WISWELL PARISH COUNCIL

Planning Application No: 3/2012/0552

Application for demolition of existing bungalow and replacement with two-storey detached dwelling

Shay Cross, Old Back Lane, Wiswell, Lancashire, BB7 9BS

#### PROPOSED PLANS AND ELEVATIONS

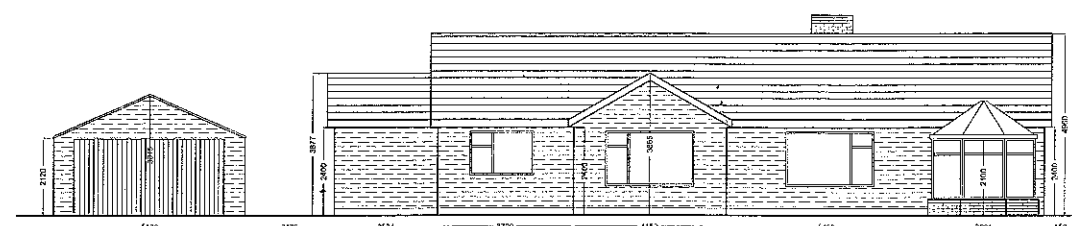
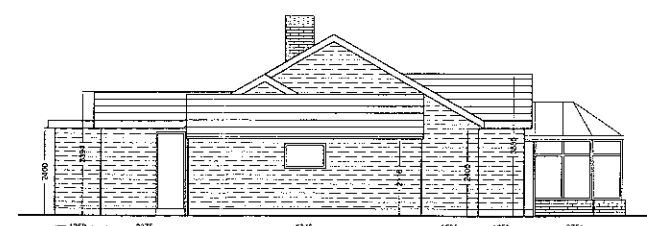
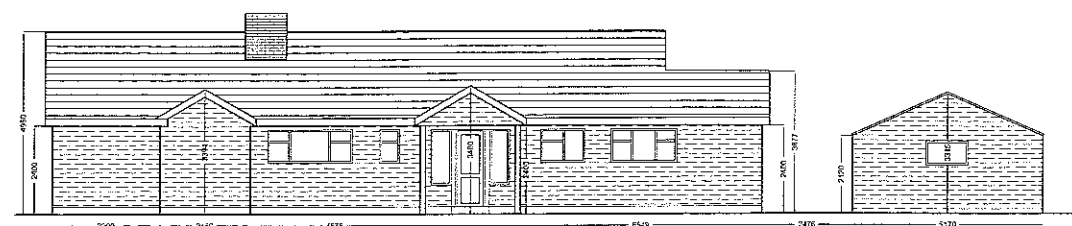
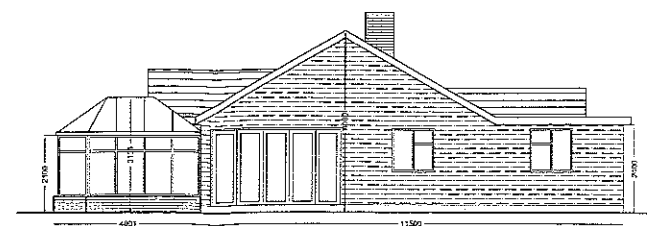
The above application has now been considered by Members of the Parish Council. Members are concerned that the height of the proposed two-storey property is not consistent with neighbouring properties. They object to the application on the grounds that it would be detrimental to the street scene due to its unacceptable size and massing.
